From: Sue Bowley on behalf of Planning
Sent: 28 February 2011 08:54
To: Janice Chapman
Subject: FW: Our Ref: 4412 re: Proposed Single Storey Double Garage - 25 Elm Grove, Barnham - Ref: EG/1/11
Attachments: 4412-3.pdf

From: Kenneth Hilton [REDACTED]
Sent: 25 February 2011 14:39
To: Planning
Subject: Our Ref: 4412 re: Proposed Single Storey Double Garage - 25 Elm Grove, Barnham - Ref: EG/1/11

ELEVATIONS & SECTIONS		NORTH
Scale	N.T.S.	Drawn By
Date	JAN 11.	Checked
Drawing Number	4412/3	K.E.H.

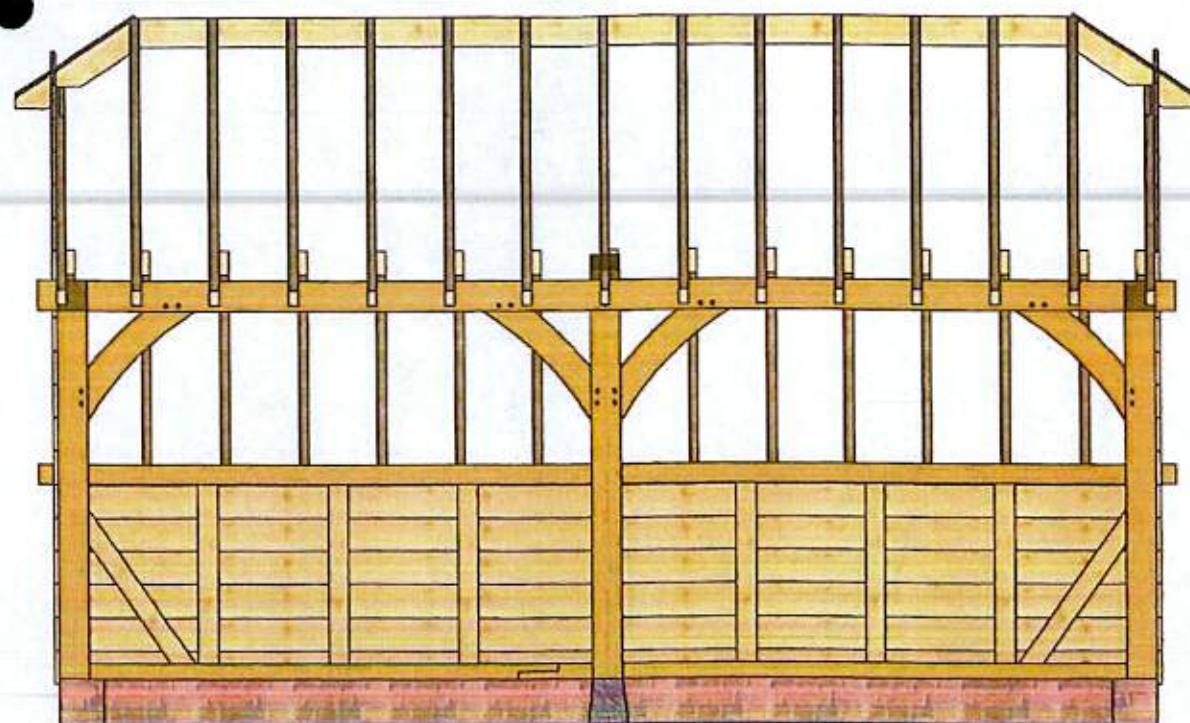
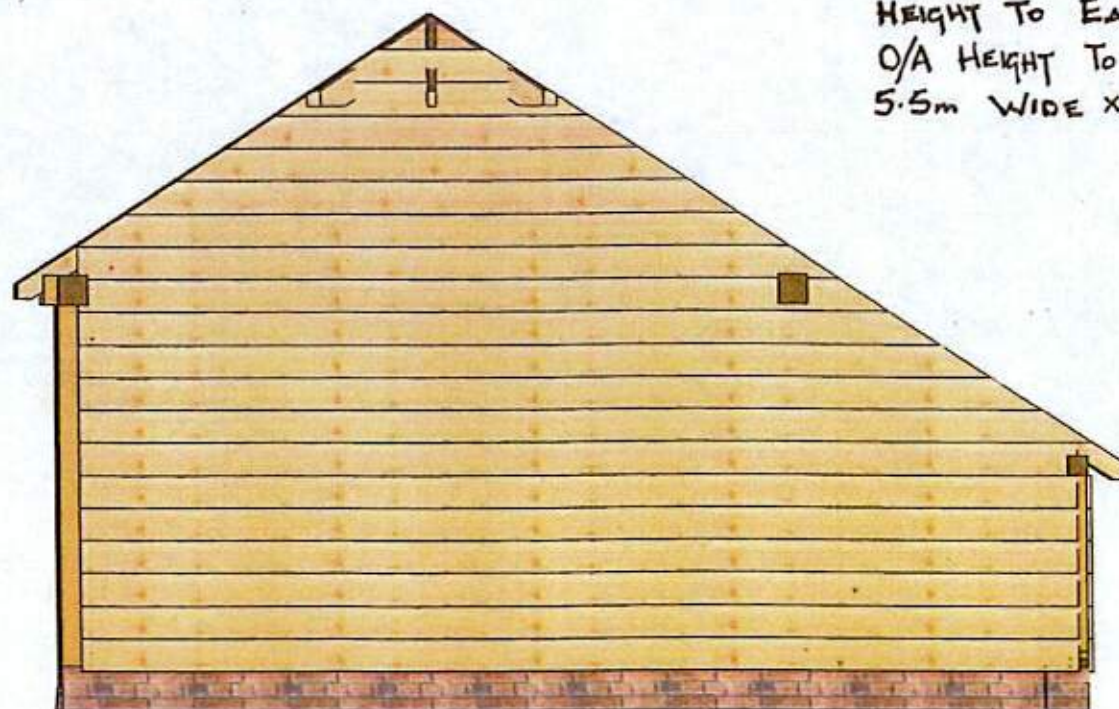
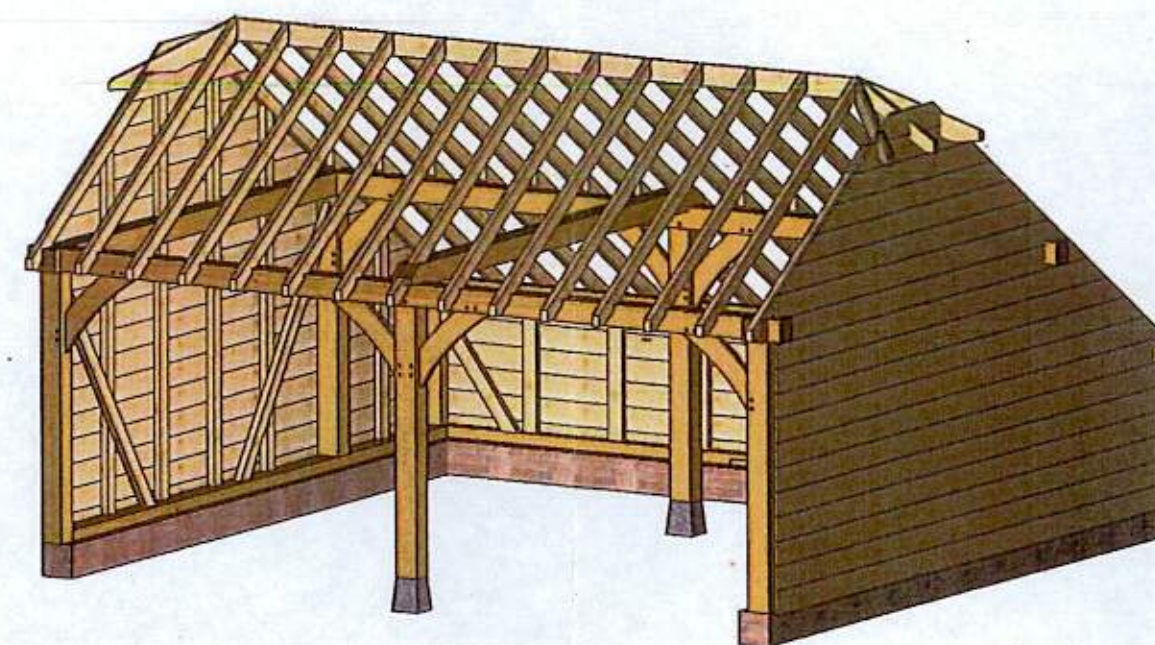
Further to our telephone conversation yesterday, I attach herewith amended drawing no. 4412/3a giving the critical overall and height dimensions of the proposed double garage.
